RE: **Encanto Apartments
Mesa Del Sol
University Blvd. and Bobby Foster Rd. SE
Grading and Drainage Plan
Engineers Stamp Date 12/27/2021 (R16D101)**

Based upon the information provided in your submittal received 1/4/2022, this plan cannot be approved for Building Permit until the following comments are addressed:

GRADING AND DRAINAGE PLAN
SHEET 1 - NE
**ENCANTO APARTMENTS
MESA DEL SOL**
MARCH, 2022

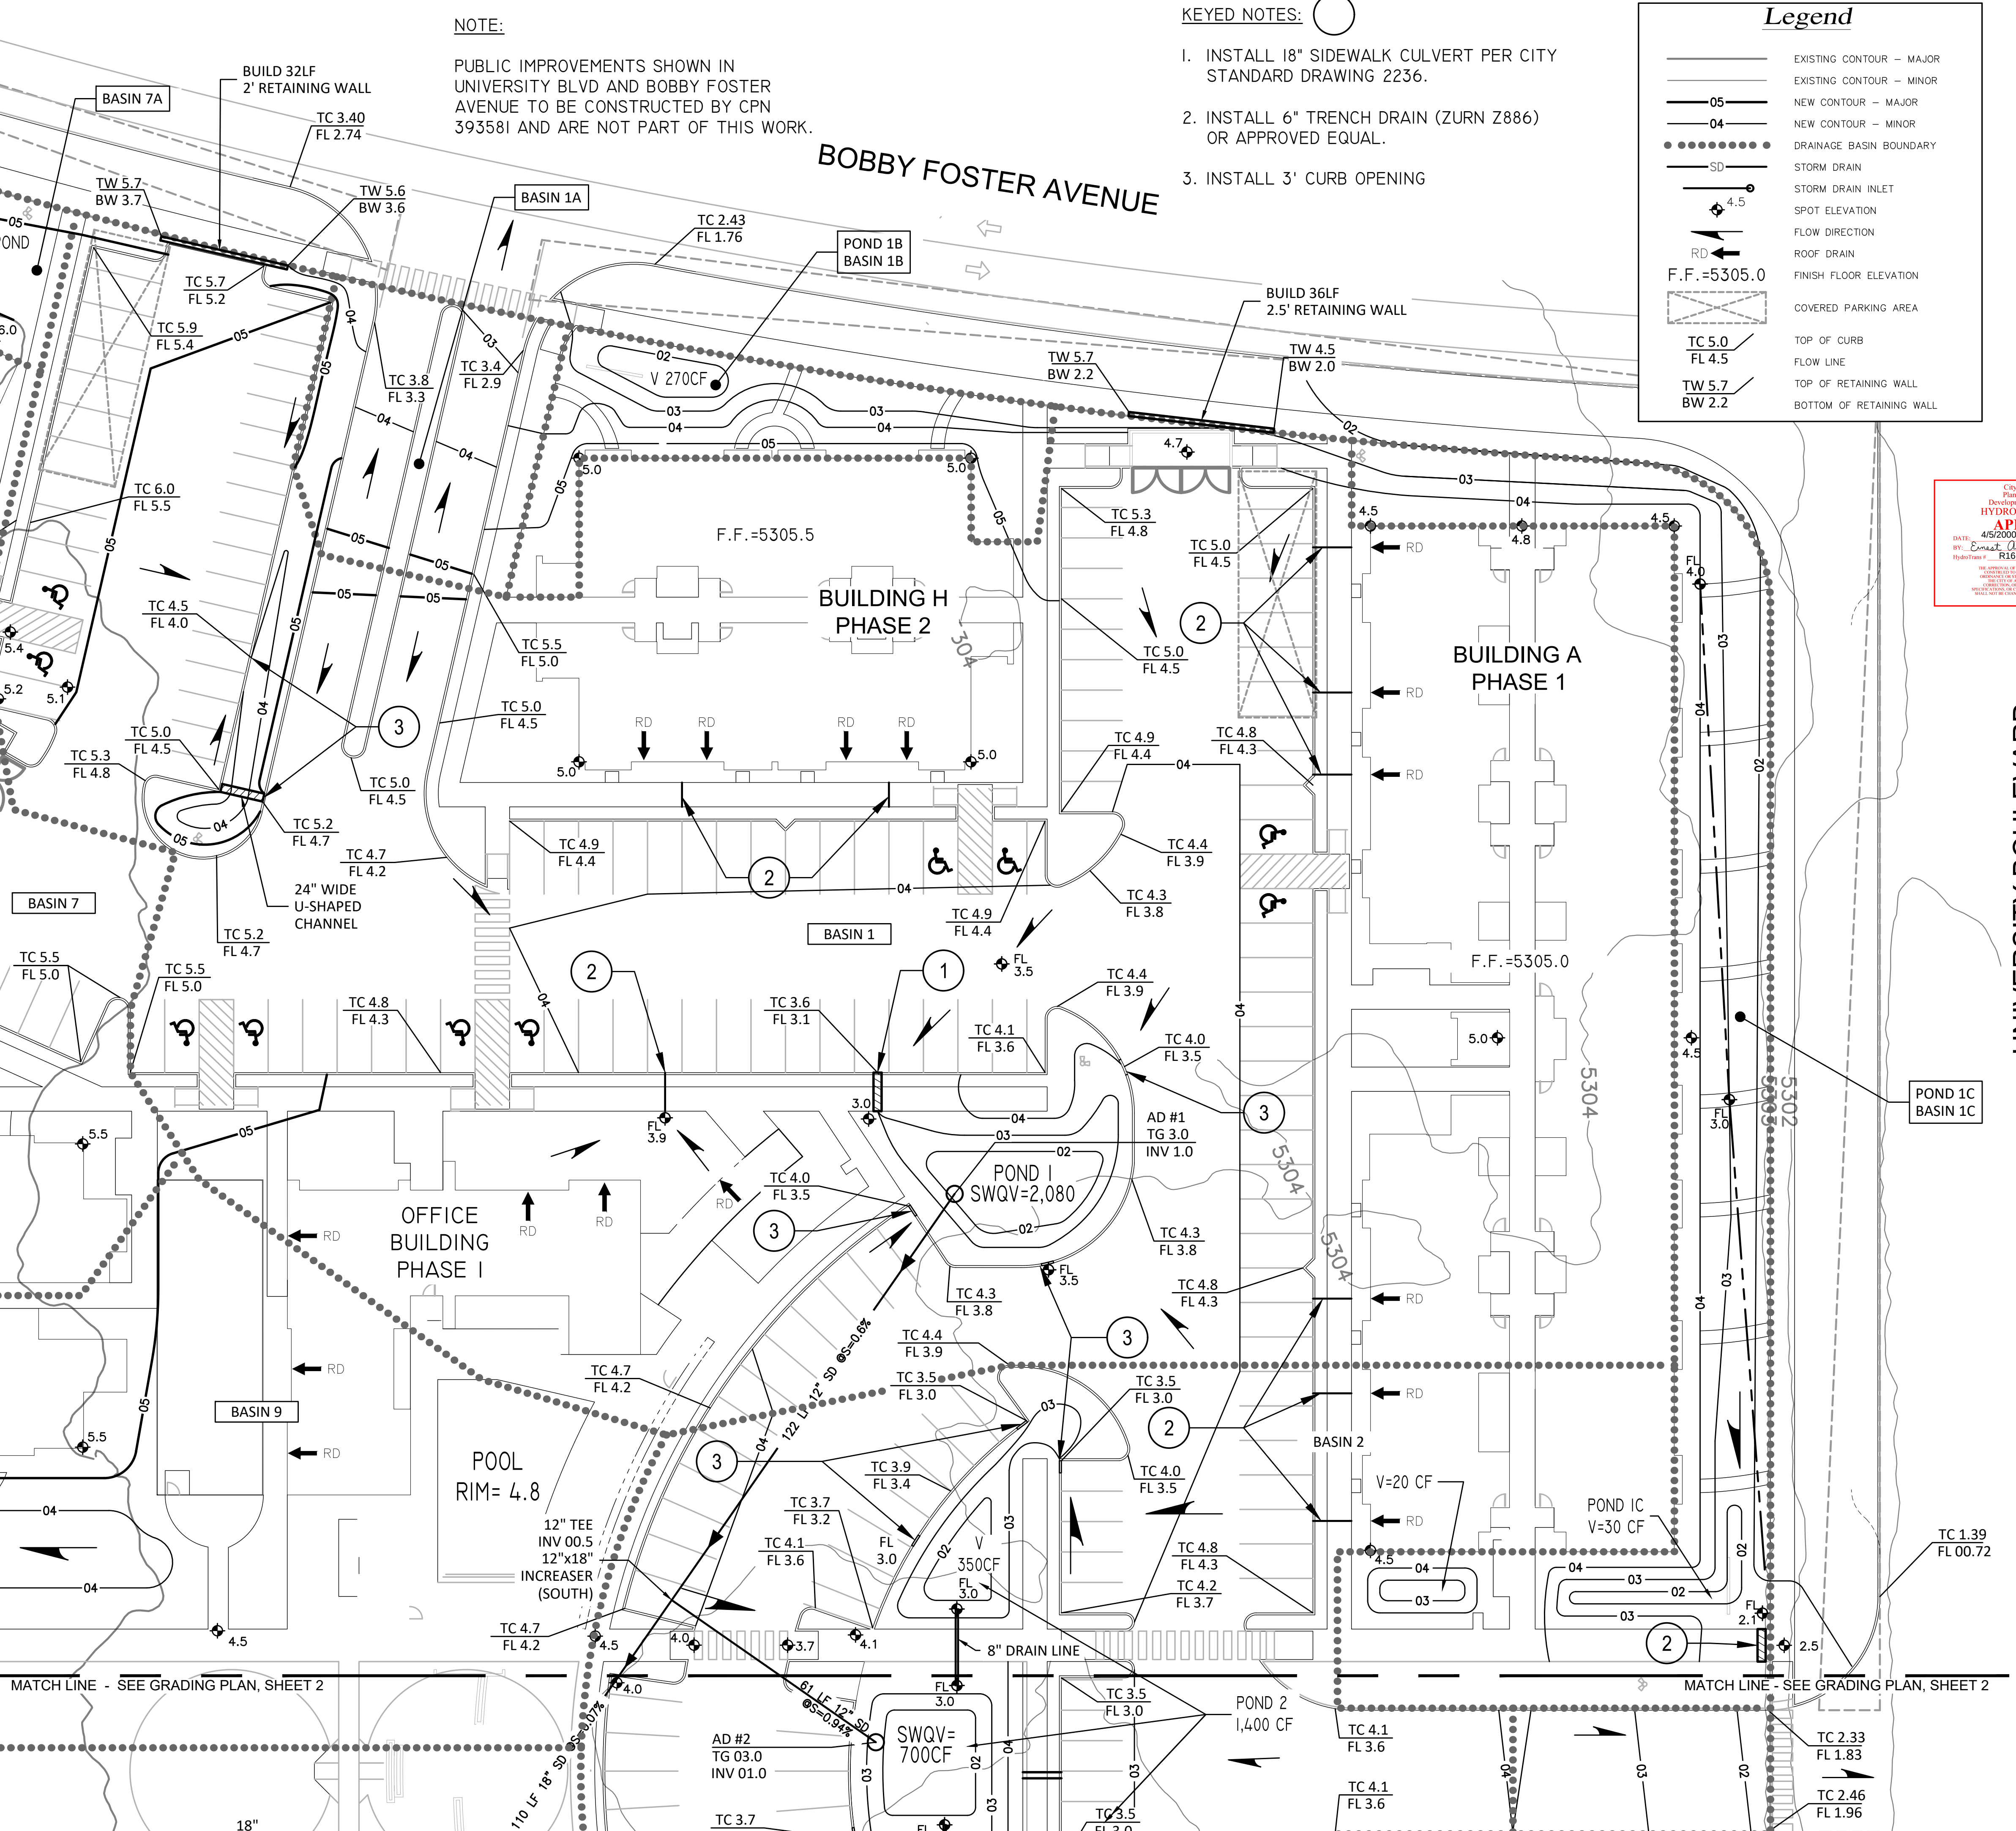
14. The pond on the NW end of Building G ties to an inlet. Call out the inlet and list top of grate elevation.
15. On sheet 1 there is a building east of Building G that is not named and it does not show what phase it is in. Please add this information.

GRADING AND DRAINAGE PLAN
SHEET 2 - SE
ENCANTO APARTMENTS
MESA DEL SOL
MARCH, 2022

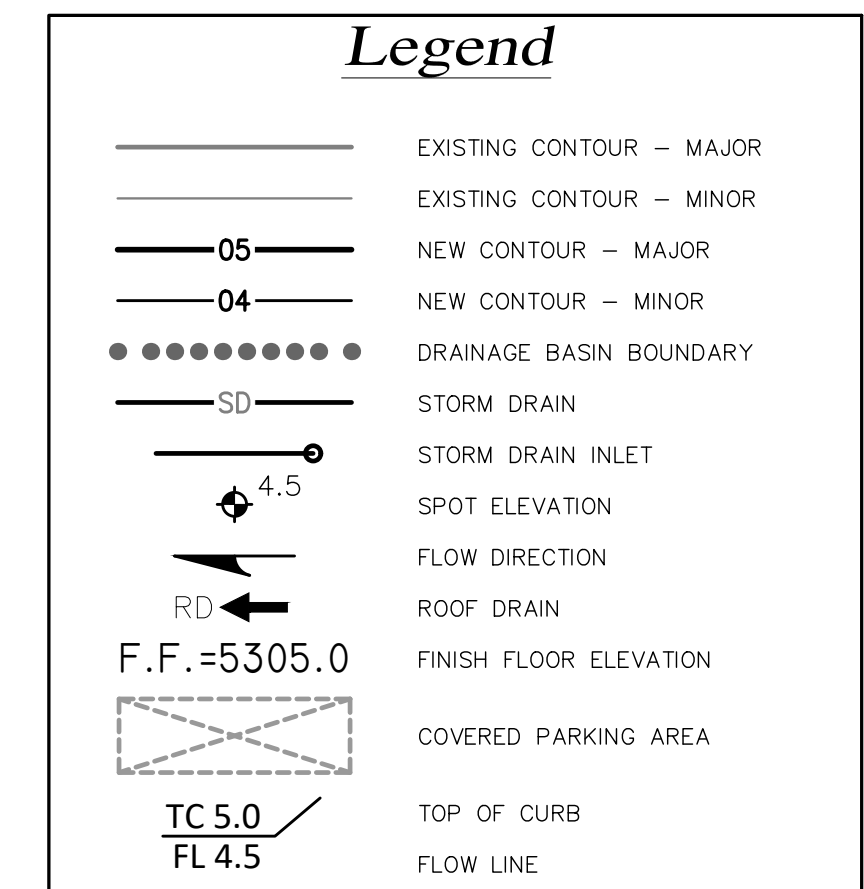
16. On sheet 2 between Buildings B and D there are two ponds connected with an 8" drain line. Based on the diameter and inverts listed, this line looks like it is very shallow. Please check to make sure you have clearance for the sidewalk running above it. Also, the southernmost pond of these two has an inlet with a top of grate elevation higher than the nearby curb opening. This inlet will not capture any flows as designed.
